Application for a Non-Material Amendment Following a Grant of Planning Permission

Killingdown Farm

20/1881/FUL

- 1) Temporary removal of hedgerow
- 2) Removal of minor swales

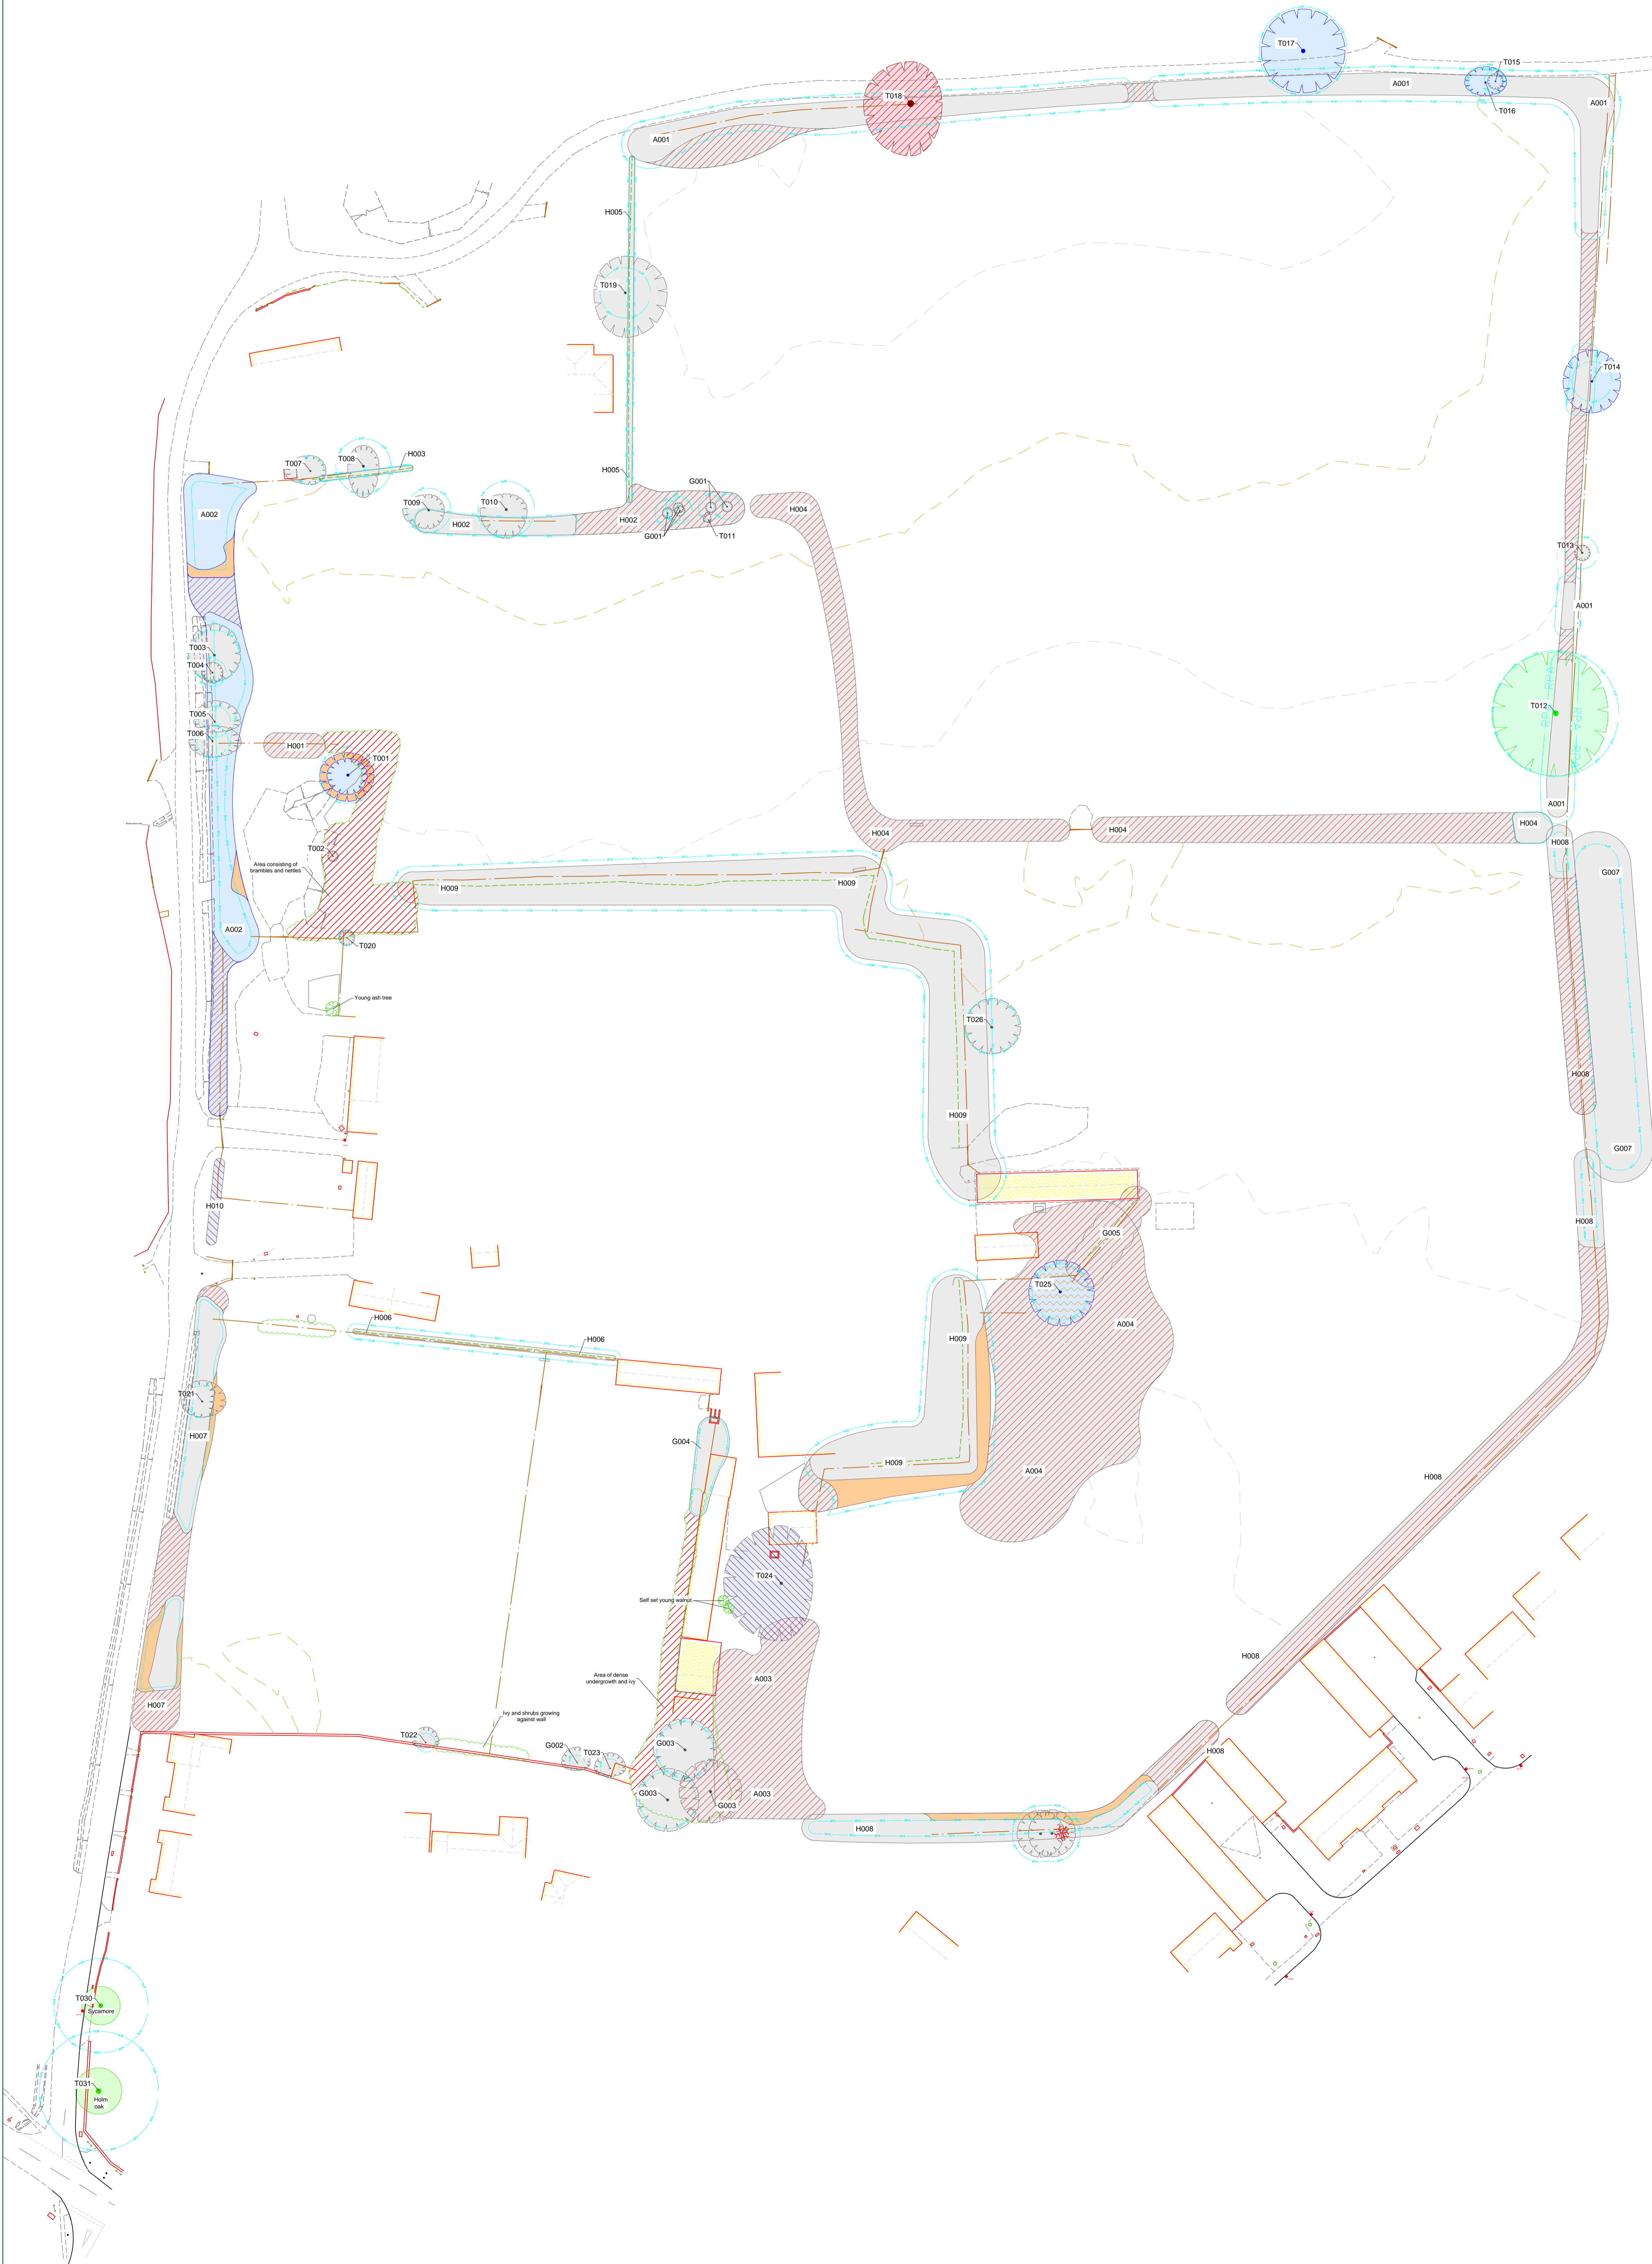
- 1) Removal of an additional length of hedgerow will allow us temporary construction access while the main drainage and the estate road is being installed. Once the permanent estate entrance is formed the temporary construction access will be closed, hoarding erected in front and new hedgerow planting will be installed.
- 2) We would like to remove a small run of minor swales at the center of the site that do not form part of the SUDS and do not connect/flow into the on-site surface water drainage, either now in the current design or in the design submitted for planning. Removal of the swales will facilitate a run of trees that will be a benefit to the development as well as making it easier for services to reach the adjacent properties.
